# Modification of Development Consent

<b>Development consent:</b>	<b>SSD 6960</b> granted by the Planning Assessment Commission on 7 March 2017
<b>For the following:</b>	Construction of the Stage 1B basement including remediation, bulk excavation, interim public domain, interim roadway, services, infrastructure and associated works.
<b>Applicant:</b>	Lend Lease (Millers Point) Pty Limited
<b>Consent Authority:</b>	Minister for Planning
<b>The Land:</b>	Lot 214 DP 1221076
<b>Modification:</b>	<b>SSD 6960 MOD 2:</b> Amendment to the structure surface level of the basement slab from a consistent level of RL 0.7 to variable levels between RL 0.7 and RL 0.9.

**End of modification  
(SSD 6960 MOD 2)**

Sheet No. 1 of 4

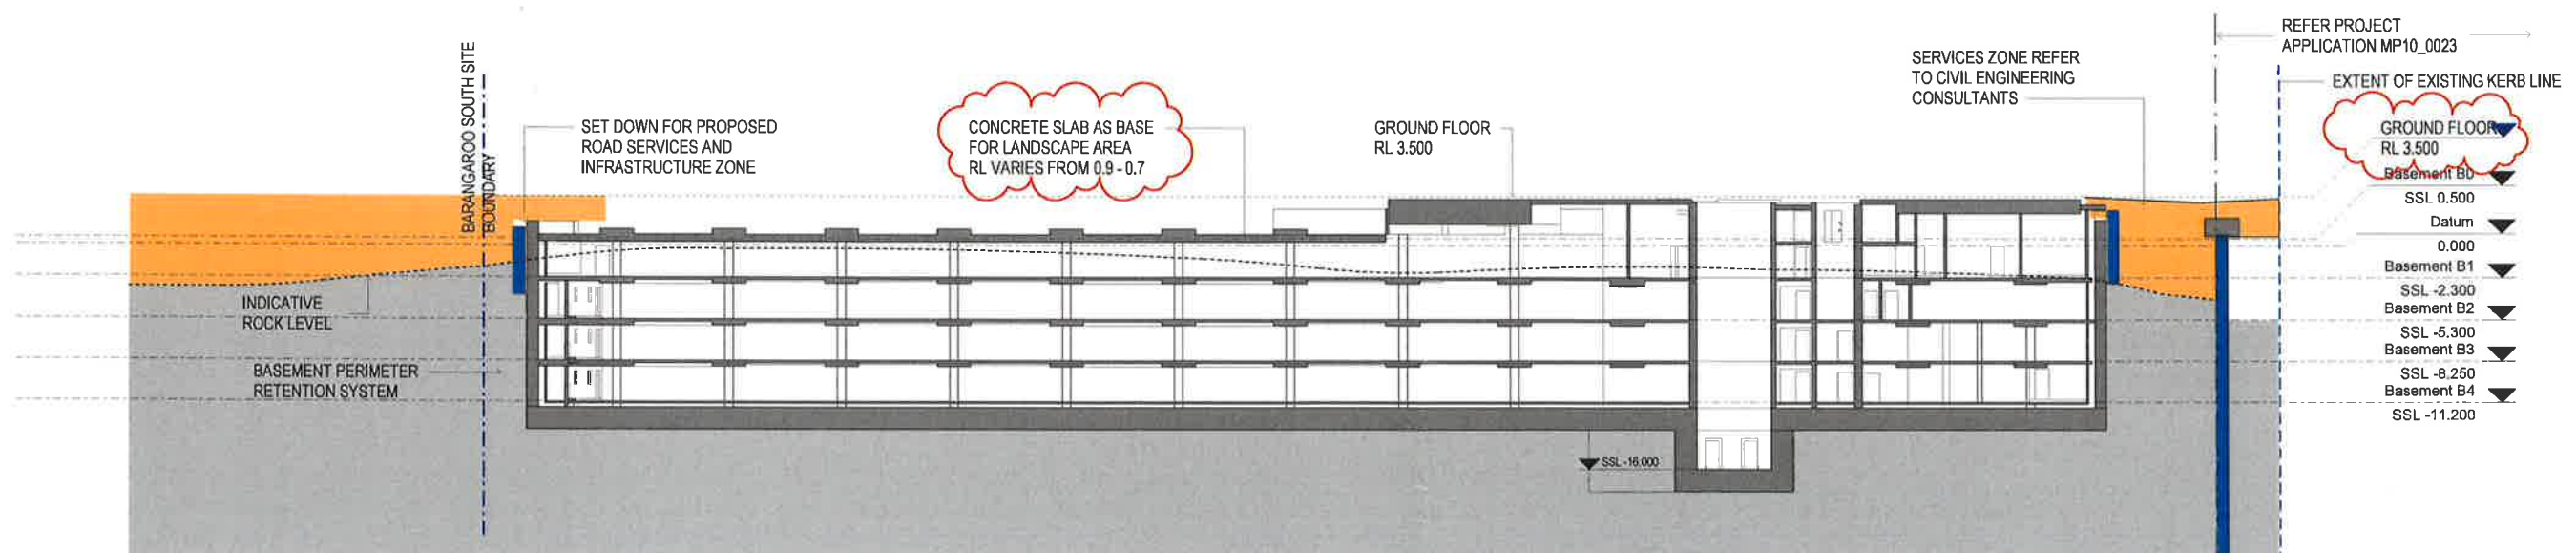
<b>Statement of Commitments in Schedule 3</b>			
<b>Architectural drawings prepared by Lend Lease Design and Renzo Piano Building Workshop and landscape drawings prepared by Grant Associates</b>			
<b>Drawing No.</b>	<b>Revision</b>	<b>Name of Plan</b>	<b>Date</b>
BB2_PA2_A000	D	Title Sheet	18/03/2019
BB2_PA2_A001	B	Aerial Location Plan	30/08/2016
BB2_PA2_A002	B	Survey Plan	19/05/2016
BB2_PA2_A003	B	Demolition, Excavation and Services Zone Plan	30/08/2016
BB2_PA2_A100	C	Basement Plan Level B0	3/08/2018
BB2_PA2_A101	D	Basement Plan Level B1	5/02/19
BB2_PA2_A102	C	Basement Plan Level B2	3/08/2018
BB2_PA2_A103	C	Basement Plan Level B3	3/08/2018
BB2_PA2_A104	C	Basement Plan Level B4	3/08/2018
BB2_PA2_A105	C	Basement Plan Level B5	3/08/2018
BB2_PA2_A300	<del>D</del> <b>E</b>	Section 01	<del>5/02/19</del> <b>14/05/19</b>
BB2_PA2_A301	<del>D</del> <b>E</b>	Section 02	<del>5/02/19</del> <b>14/05/19</b>
BB2_PA2_A302	<del>D</del> <b>E</b>	Section 03	<del>5/02/19</del> <b>14/05/19</b>

Sheet No. 3 of 4

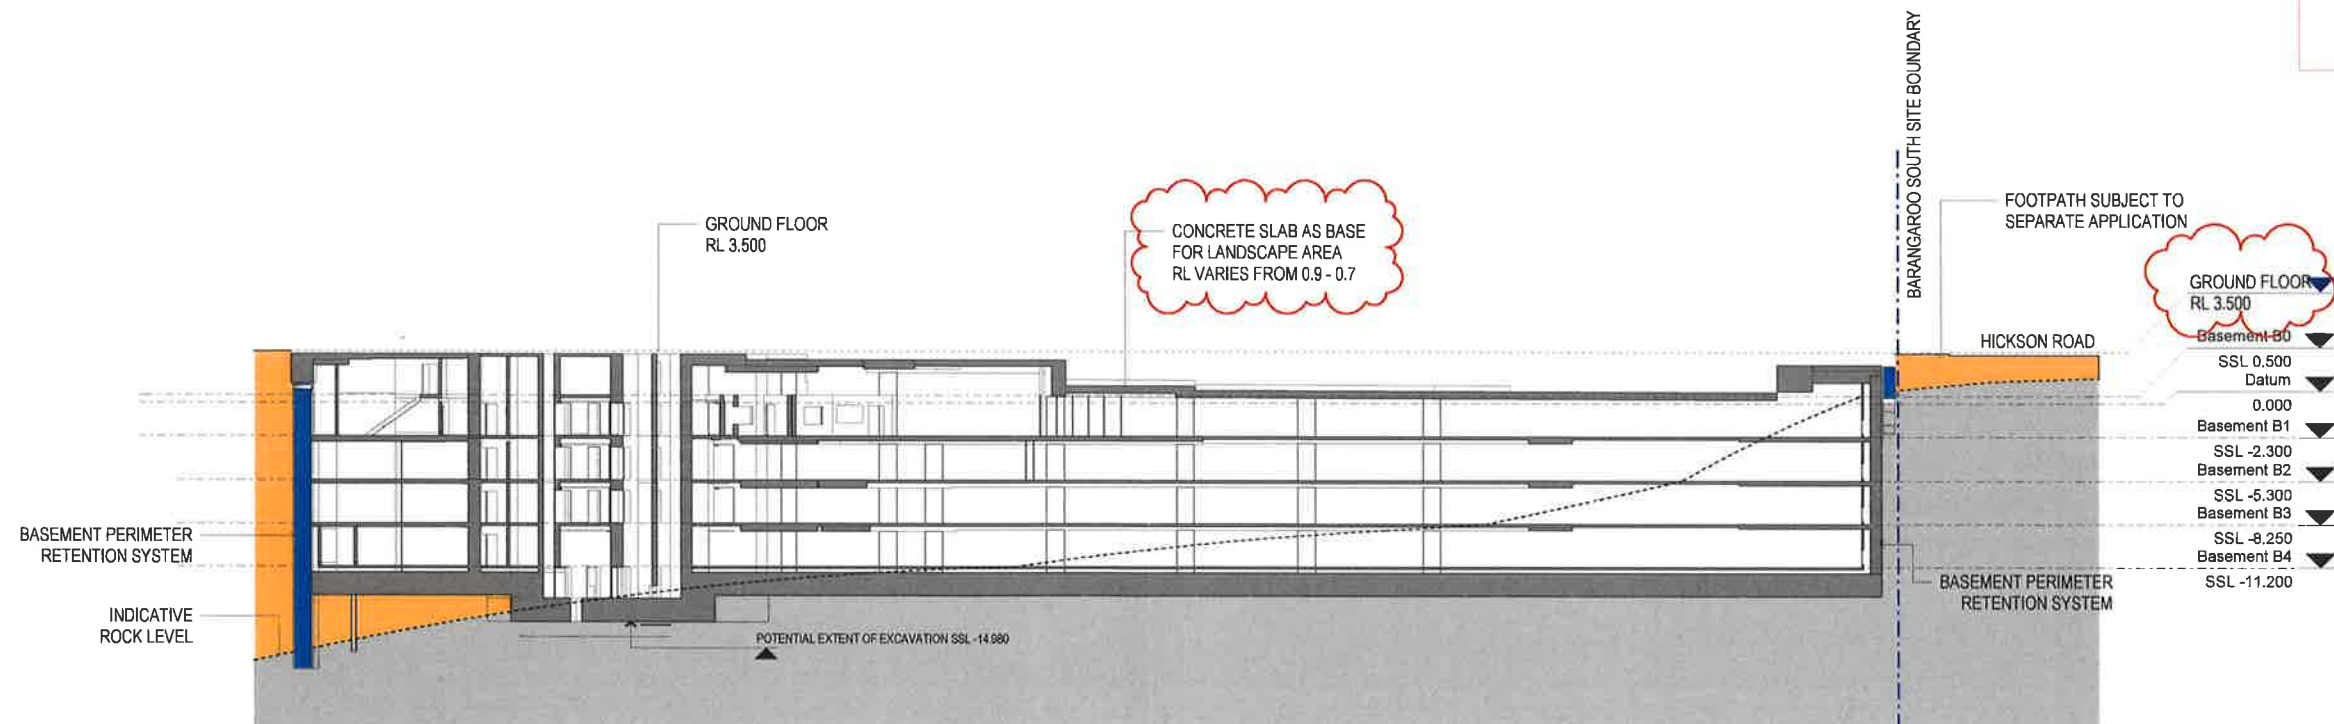
BB2_PA2_A303	<del>D</del> <b>E</b>	Section 04	<del>5/02/19</del> <b>14/05/19</b>
BB2_PA2_A400	C	Building Elements – Ground Floor	3/08/2018
BB2_PA2_A401	C	Building Elements – Podium P1	3/08/2018
BB2_PA2_A402	C	Building Elements – Podium P2	3/08/2018
BB2_PA2_A501	C	Building Elements – Elevations	3/08/2018
RPB430_GE_BMT 000	I	Extent of Landscape Works	31/07/2018
RPB430_GE_BMT 001	N	General Arrangement	31/07/2018
RPB430_SE_BMT 002	M	Section: Watermans Quay	26/08/2016
RPB430_SE_BMT 003	M	Section: Barangaroo Avenue	26/08/2016
RPB430_SE_BMT 004	H	Section: Hickson Road	26/08/2016
RPB430_SE_BMT 005	I	Section: Watermans Quay (Northern Footpath)	26/08/2016
